Subject: FW: The Moorcock Inn, Slaiburn Road, Waddington - Application 3/2014/0592

From: Lorimer, Elliott [<mailto:Elliott.Lorimer@lancashire.gov.uk>]
Sent: 18 September 2014 15:34
To: Colin Sharpe
Cc: 'stephen@wovenart.co.uk'
Subject: The Moorcock Inn, Slaiburn Road, Waddington - Application 3/2014/0592

Drawing Title PROPOSED ROOF PLAN		
Scale 1:200 @ A1	Date JUNE 2014	Drawn TB

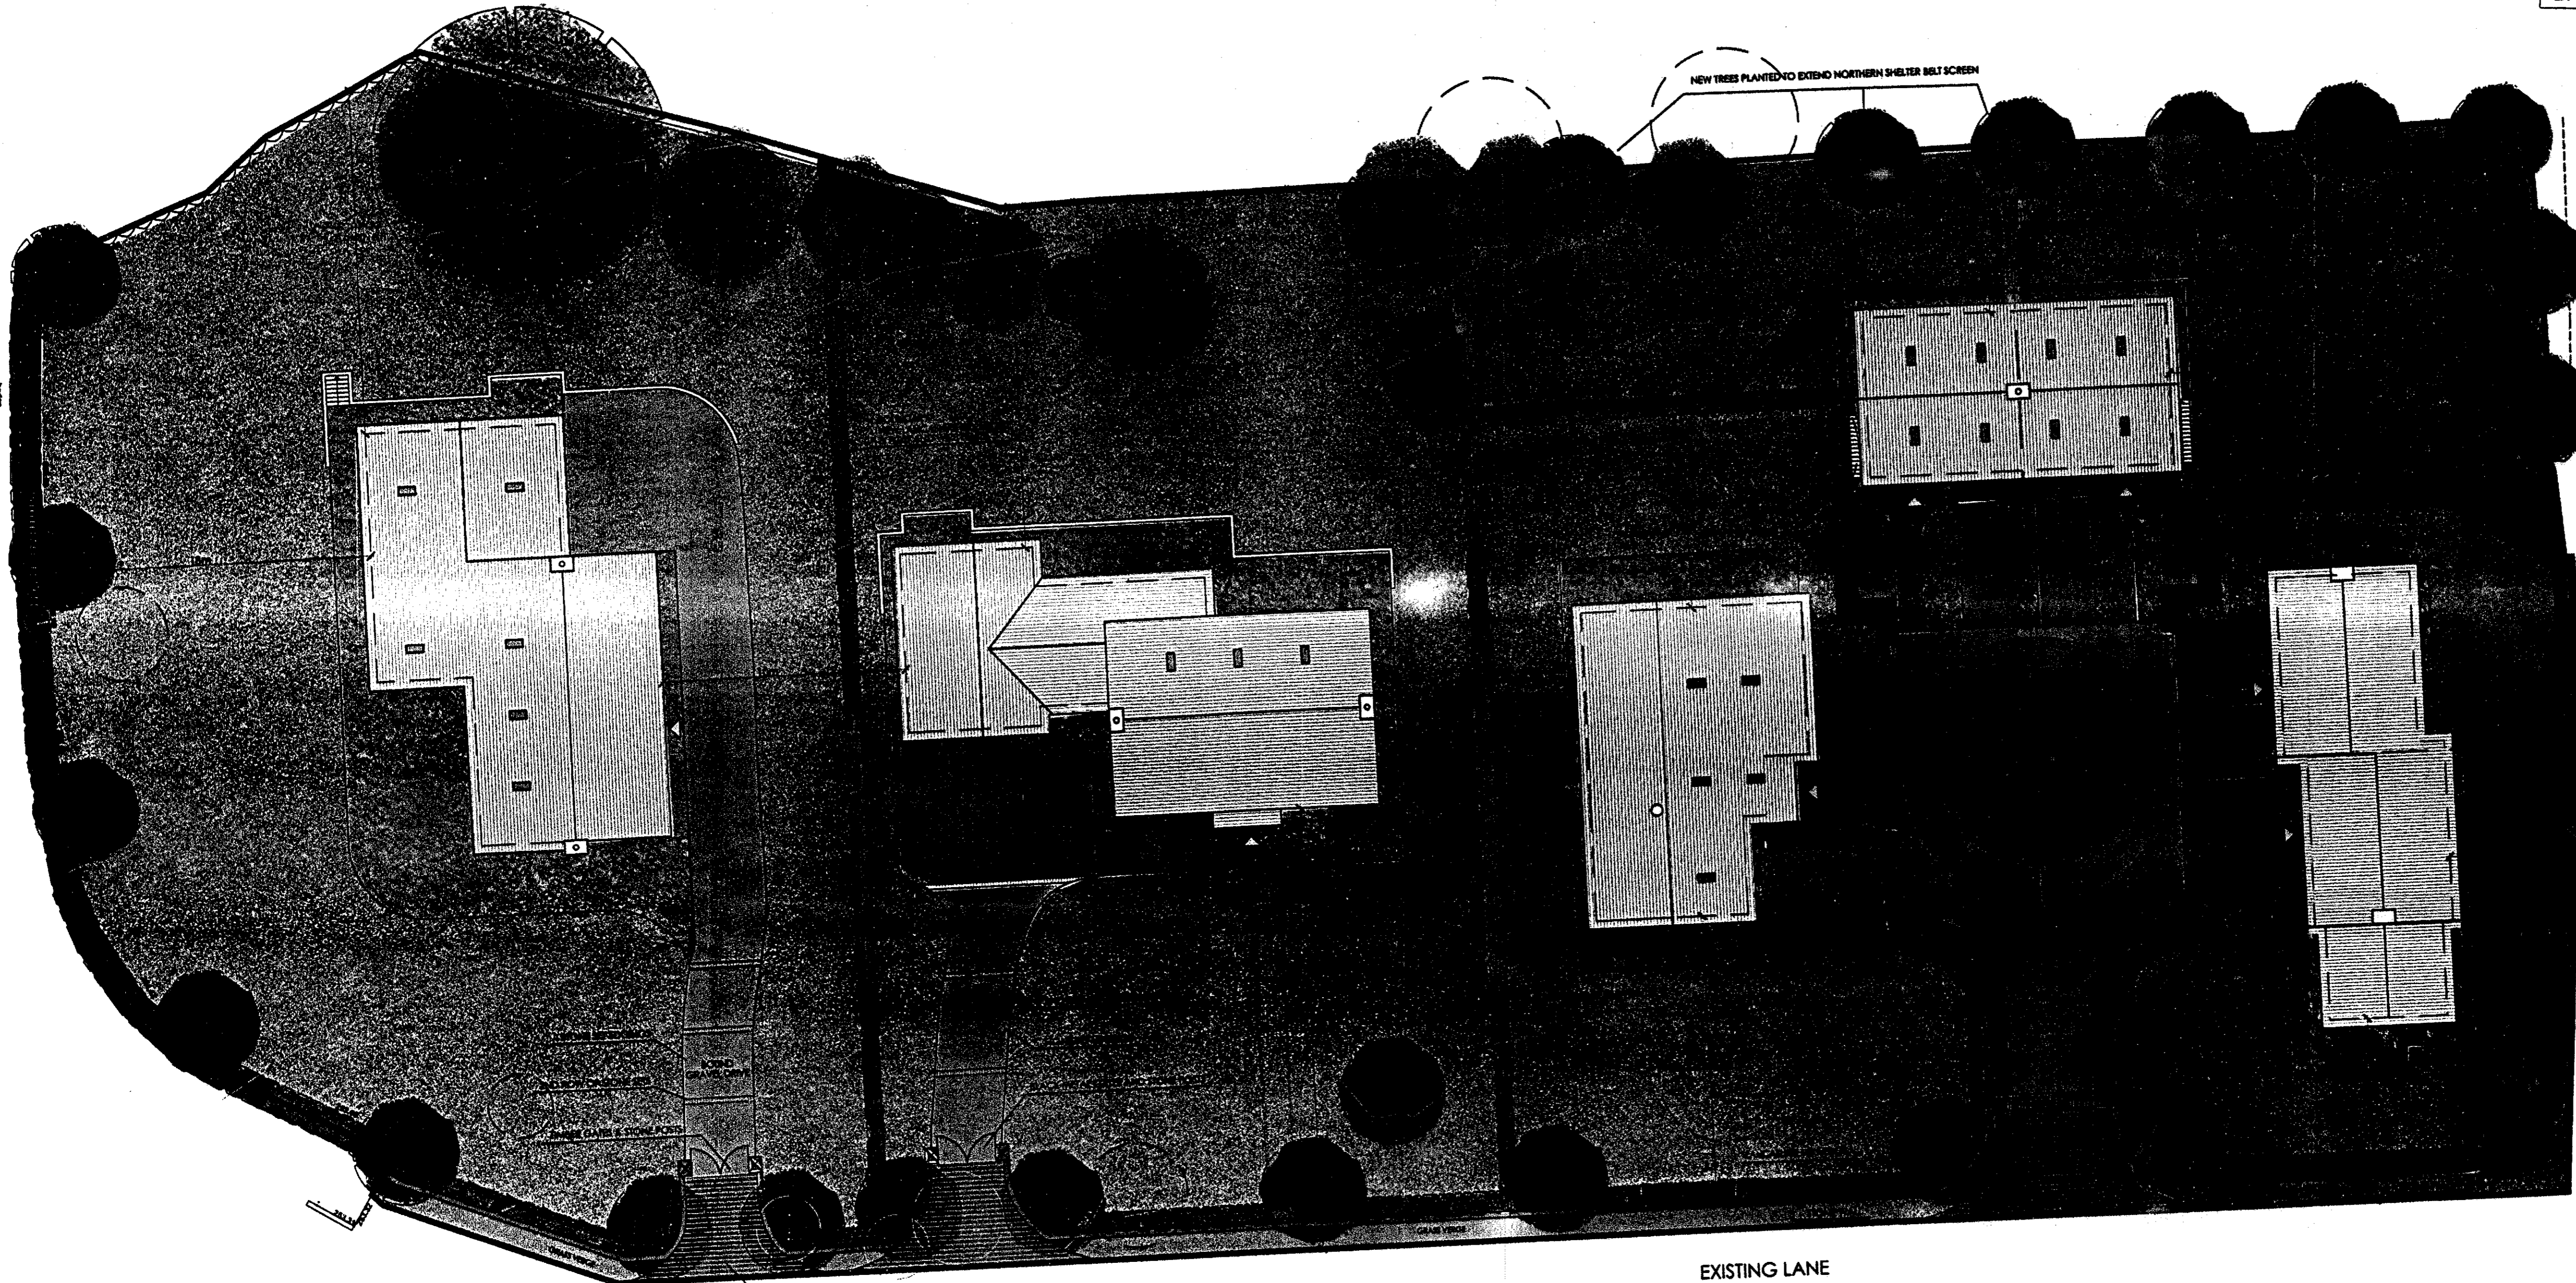
- a) The hedgerow to be established along the Slaiburn Road frontage should be inter-planted with some hedgerow trees.
- b) Native trees and shrubs should make up the bulk of the planting although ornamental varieties would be okay within the gardens. Conifers are not appropriate for the landscape character and should not be planted.
